From: Simon Davis
Sent: 13 September 2021 13:57
To: Queenie Cheng [REDACTED]
Subject: RE: [External]RE: M/109/21/PL 188 Elmer Road

Further to the below, I have today had a meeting with the team leader and have agreed that we can support the application.

Basic Section A-A

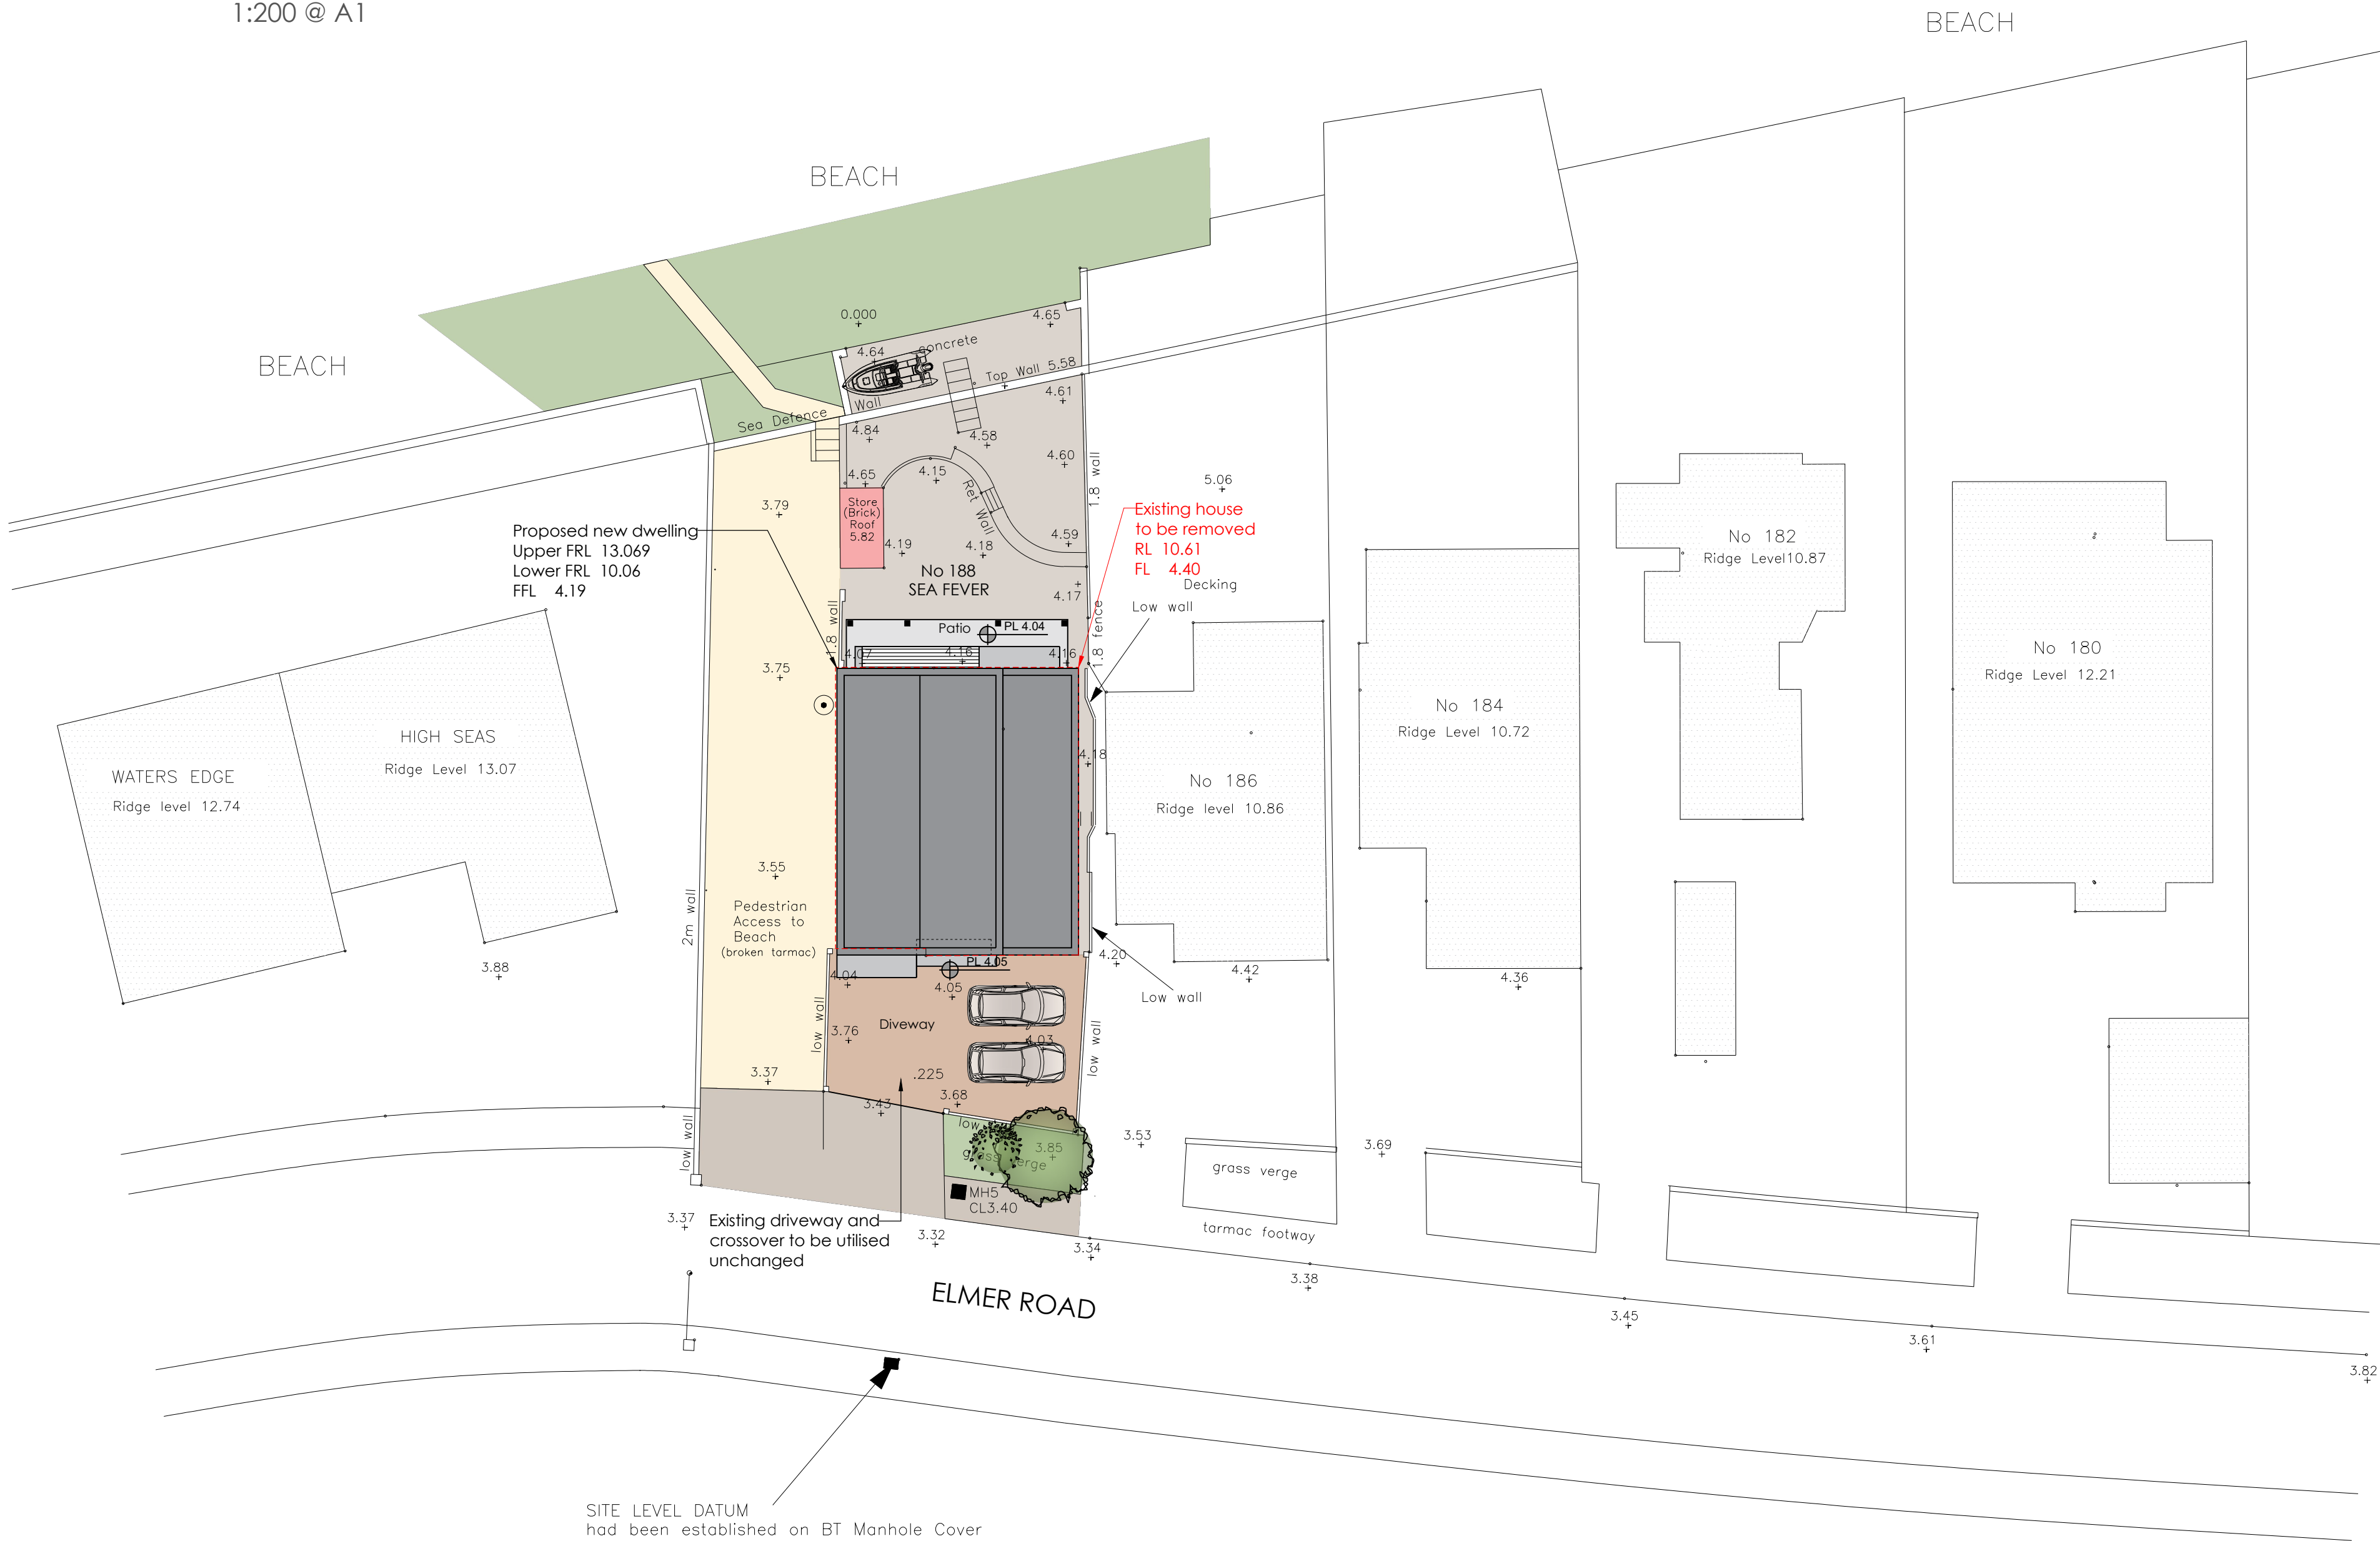
I have a slight concern with the upper floor west facing flank windows. I note that the first floor kitchen and second floor bathroom windows appear to be high level but can you amend the internal section to confirm the height of these.

West Elevation

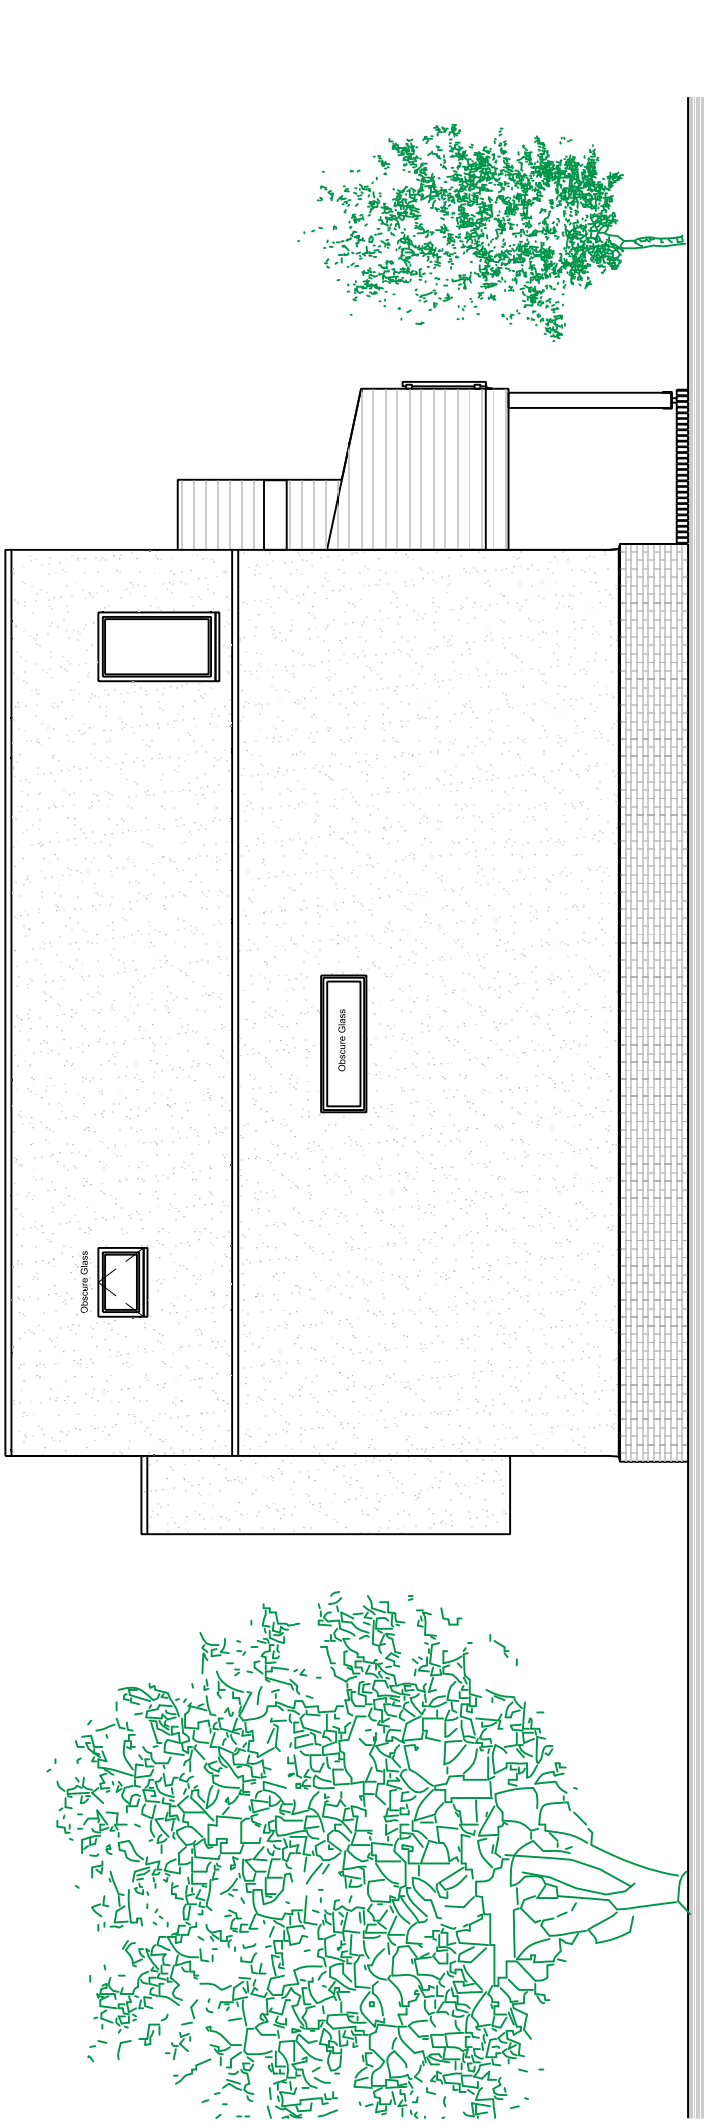
There is also a second floor secondary bedroom window on the west flank. This is normal height and from the plans, it looks like it may allow views of the neighbours garden. As it is a secondary window, would you agree to it being obscure glazed and non-opening? If so can you indicate this on the plans.
